Our ref: Q200424/el/el3
Your ref: 20/02779/REM
Email: Emma.lewis@quod.com
Date: 21 September 2021

Non-Material Amendment - Catalyst Bicester

The application seeks approval for a non-material amendment (NMA) to modify Reserved Matters approval ref. 20/02779/REM.

03 UNIT 4  
005 / roof plan

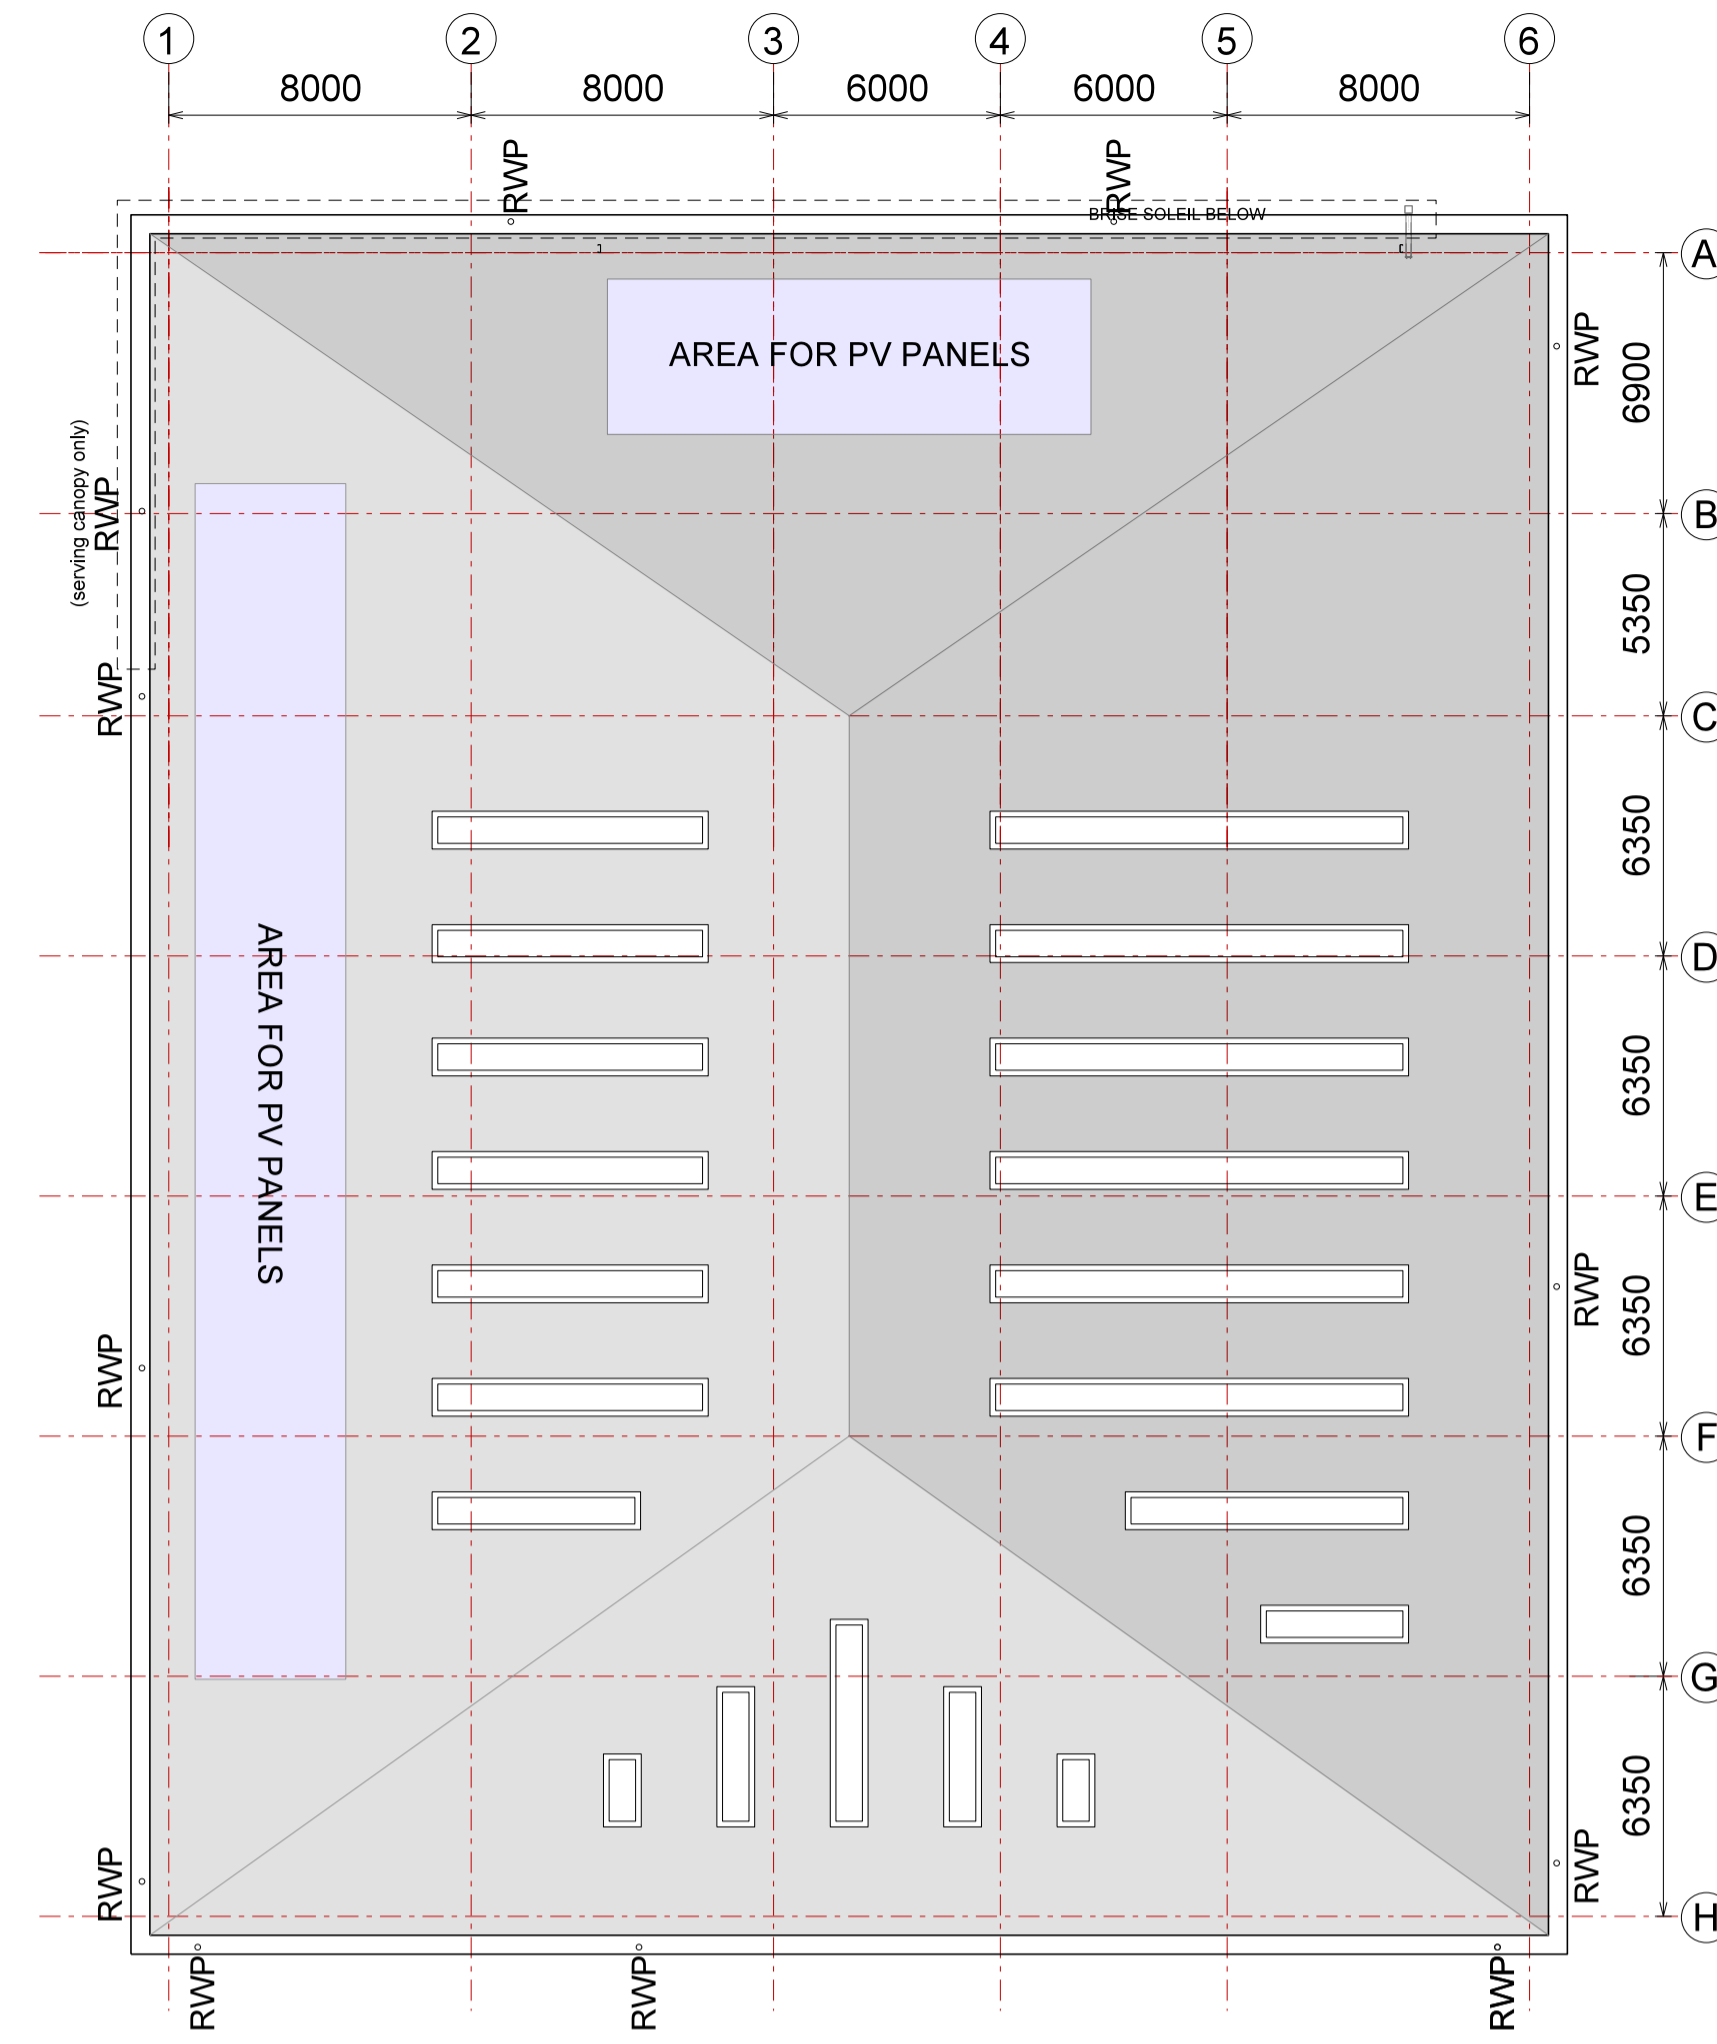
Through the installation of additional mezzanine floor space the GIA of Phase 1 will increase to 5,490sqm (an additional 364 sqm, which amounts to an increase of just 7%), and therefore will not conflict with Condition 24 of 19/01740/HYBRID which states that “*The development hereby permitted shall comprise a maximum floorspace of 16,800sqm...*”.

Further, whilst the mezzanine floorspace is intended to be used for office uses ancillary to the main operation of the units, the quantum of office uses will still sit comfortably under the 5,880 sqm permitted by the outline planning permission (also set out at Condition 24). The total mezzanine floorspace across the whole of Phase 1 is 1,527 sqm.

Drawing Title.  
**UNITS 1-3  
ELEVATIONS**

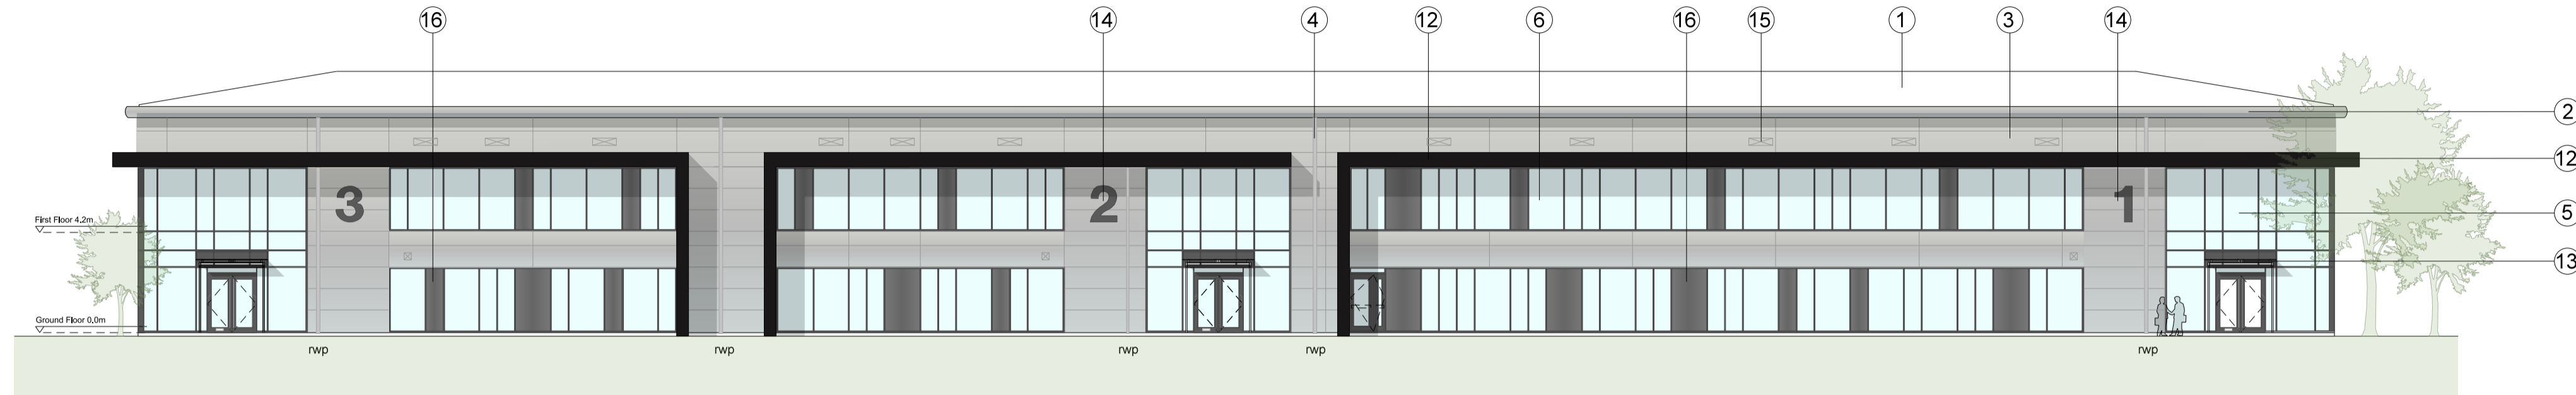
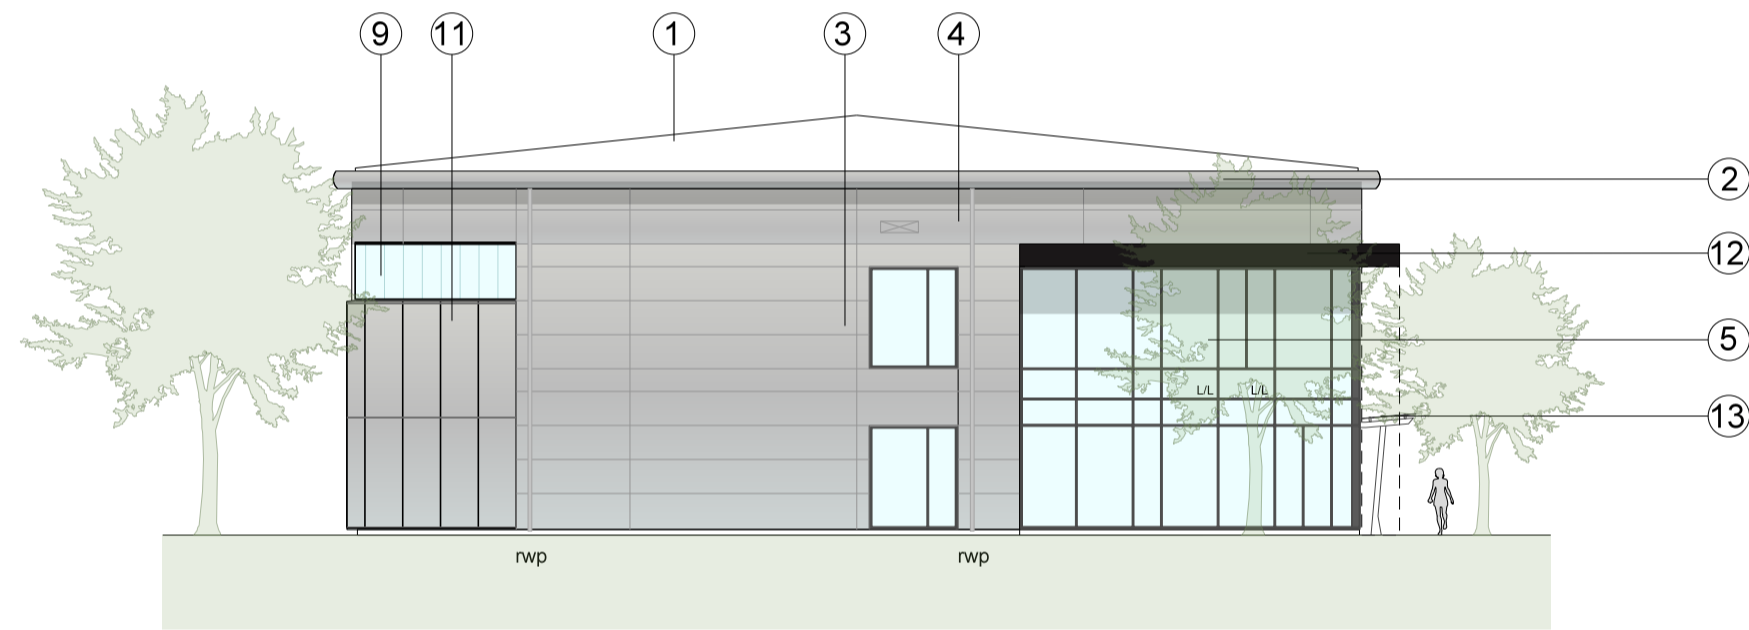
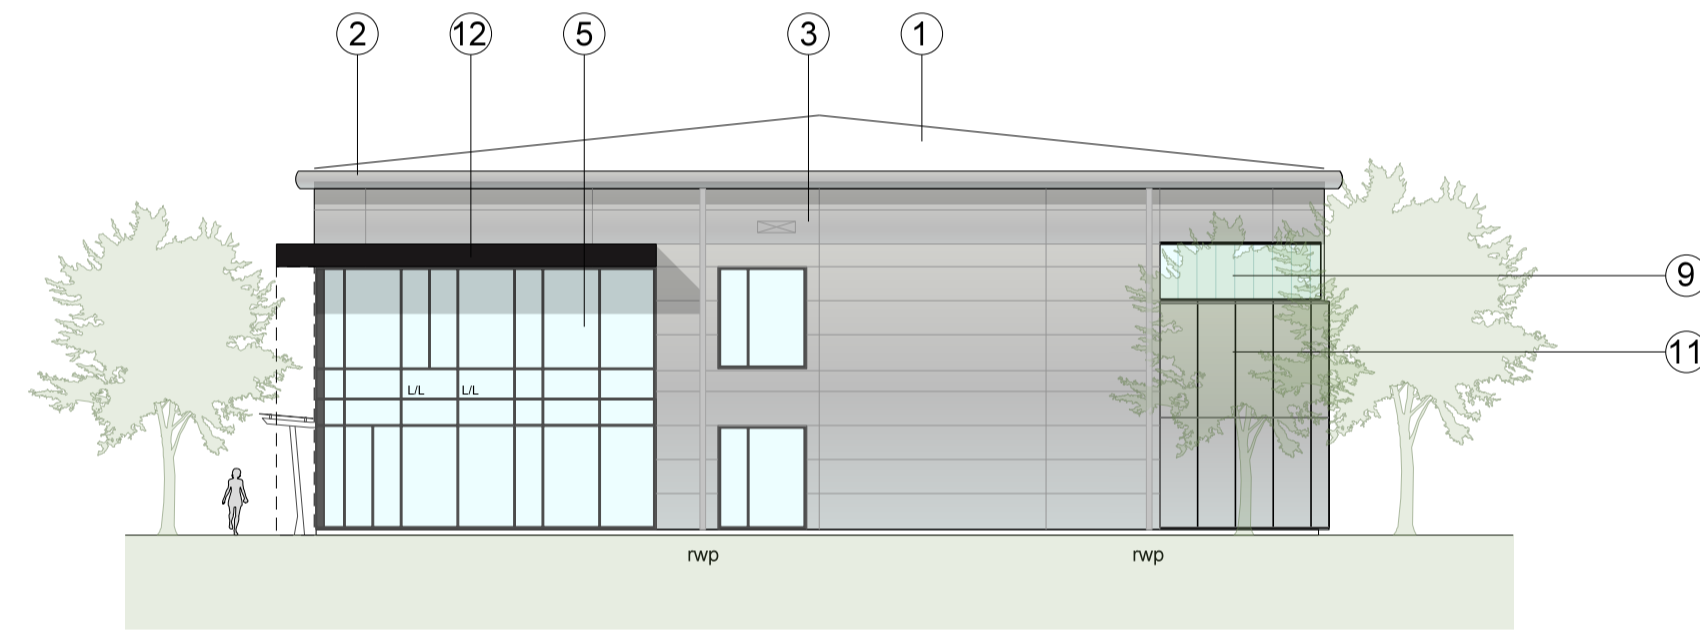
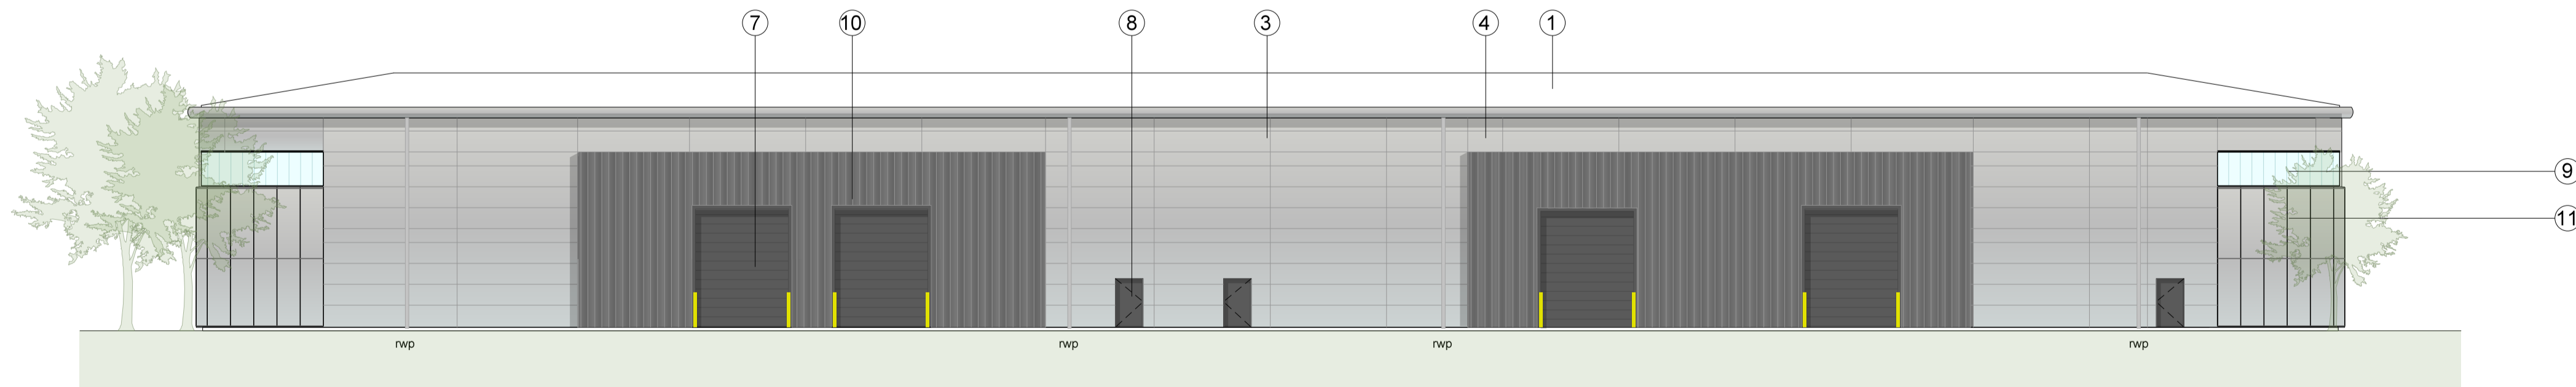
Additional windows have also been introduced to the side elevations of Units 1-3, which will enable natural lighting and ventilation of the mezzanine space.
